Our reference: ECM: 8712576
Contact: Sandra Fagan
Telephone: (02) 4732 7992

27 June 2019

**Notice of Exhibition – St Marys Intermodal (SSD 7308) at
Forrester Road, St Marys**

I refer to your email dated 29 May 2019 regarding the above proposal for the development of the St Marys Intermodal which involves the construction of an intermodal terminal and container park.

Figure 2-4 – Proposed Development Layout

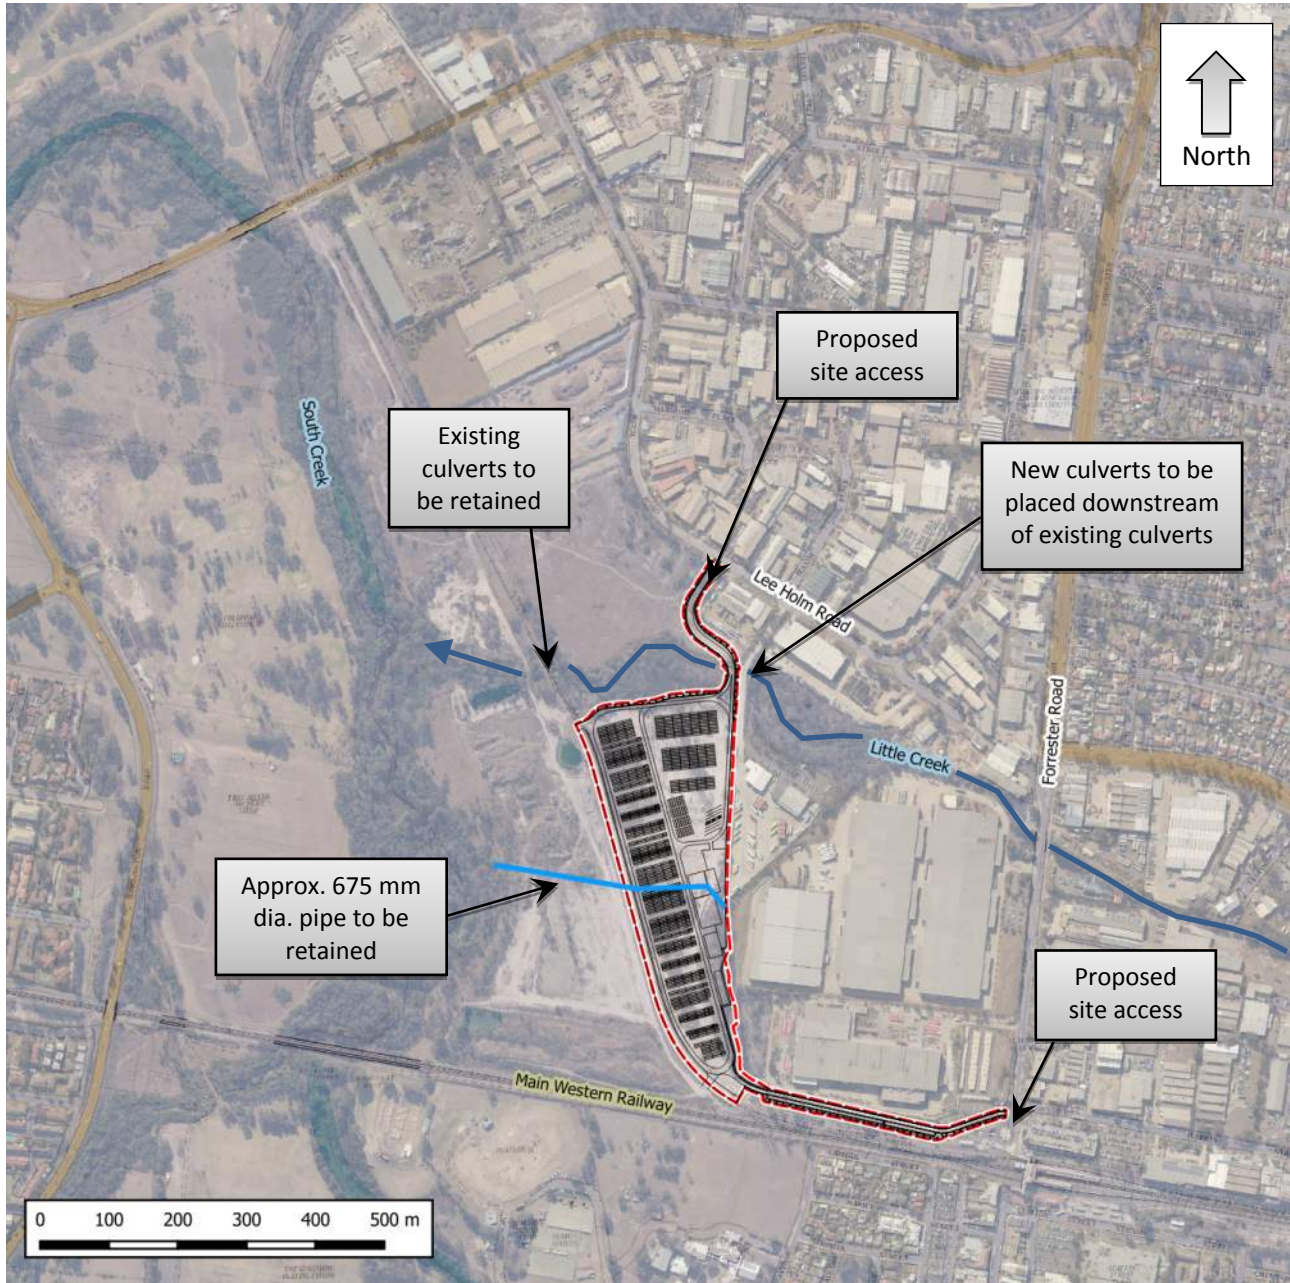
The proposed access via Lee Holm Drive is not acceptable because Lee Holm Road has a narrow roadway with multiple fronting driveways and land use activities. In addition, the B-double turn paths shown in Figure 7.4 of the TTA at the Lee Holm Drive access driveway use the full road width and full driveway

width which is also not acceptable. Two-way truck use and car use at the Lee Holm Drive driveway is not acceptable. There was no assessment of SIDRA/swept path for the Lee Holm Drive/Christie Street which the applicant intends to use for both heavy vehicles including 26m B-double truck access and likely car access.

The B-double turn paths shown in Figure 7.3 of the TTA at the Forrester Road access driveway use the full road width and full driveway width which is also not acceptable. Two-way truck use and car use at the Forrester Road driveway is not acceptable. This is compounded by the existing traffic movements at the southern end of Forrester Road, accessing the commuter car parks, 'Kiss and Ride' area and commuter pick up and drop off area from the Bus Stop.

- Sealed pedestrian and cyclist access is to be provided from the southern end of Forrester Road (near St Marys Station) to the site;
- The car park entry / exit should be separate from the heavy vehicle entry / exit driveways;

- The access driveway widths must accommodate swept movements of the largest vehicle servicing the site and be designed to conform with AS 2890.2;
- Sight distance requirements and driveway widths are to be met in accordance with AS/NZS 2890.1: 2004 and Council requirements. This is to include the requirements set out in AS 2890.1 Figure 3.2 Sight Distance Requirements at Driveways and Figure 3.3 Minimum Sight Lines for Pedestrian Safety. Also, AS 2890.2 Figure 3.3 Sight Distance Requirements at Access Driveway Exits and Figure 3.4 Minimum Dimensions for Access Driveway Sight Splays for Pedestrians;

Figure 5-4 – Little Creek PMF Flood Hazard and South Creek PMF Extent

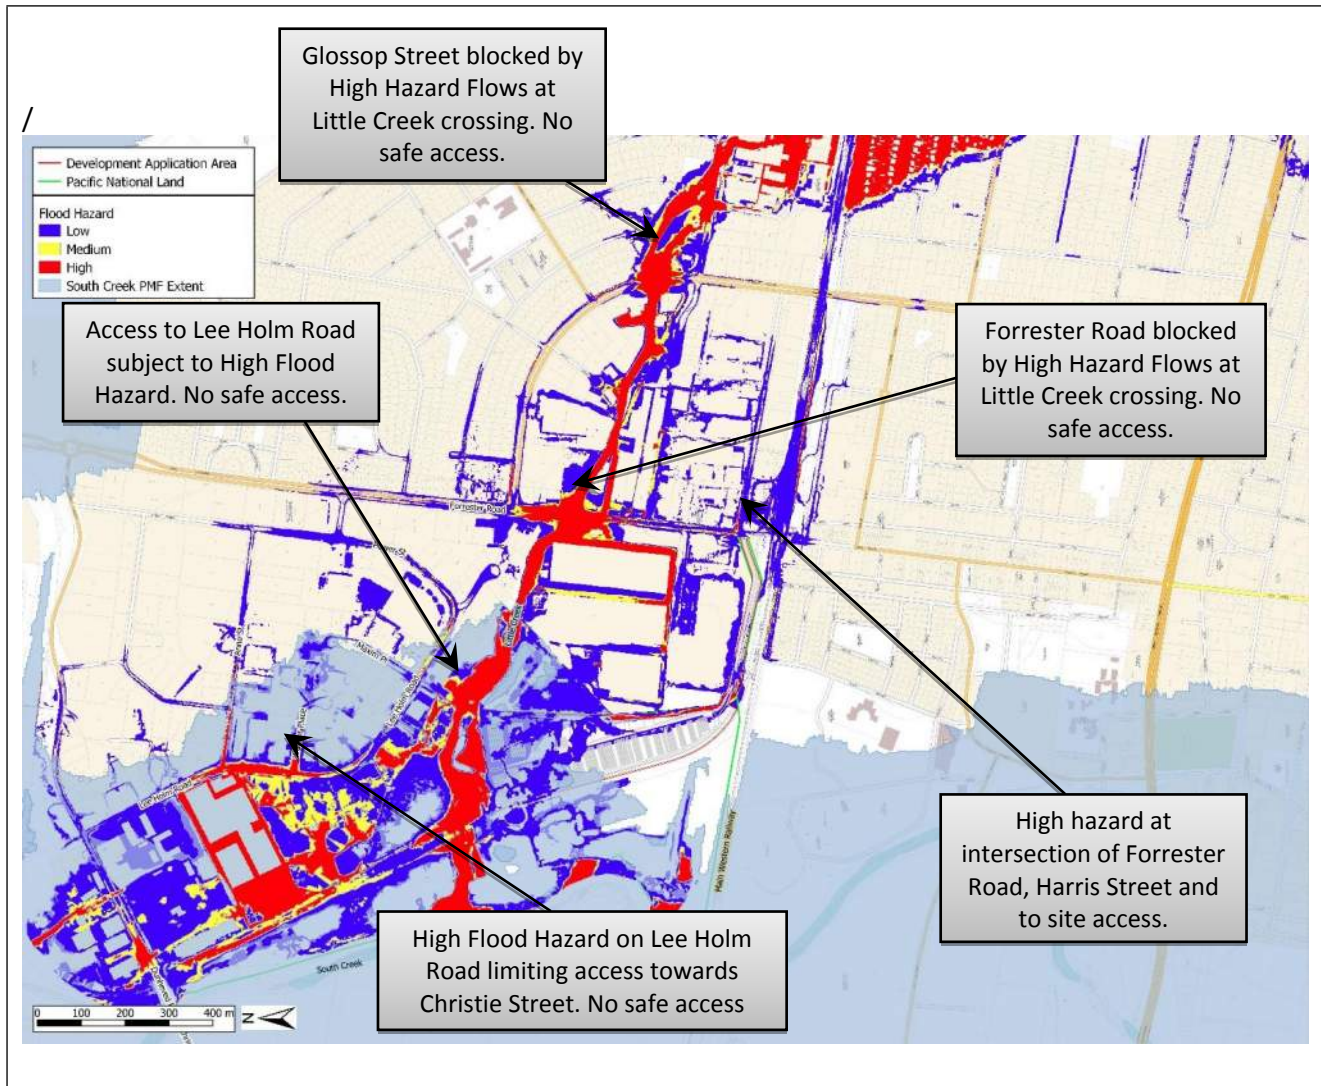
- It is also proposed to have “shelter-in-place” to manage flood evacuation. This is not supported. In any case a flood evacuation management plan will be required to address the flood evacuation;
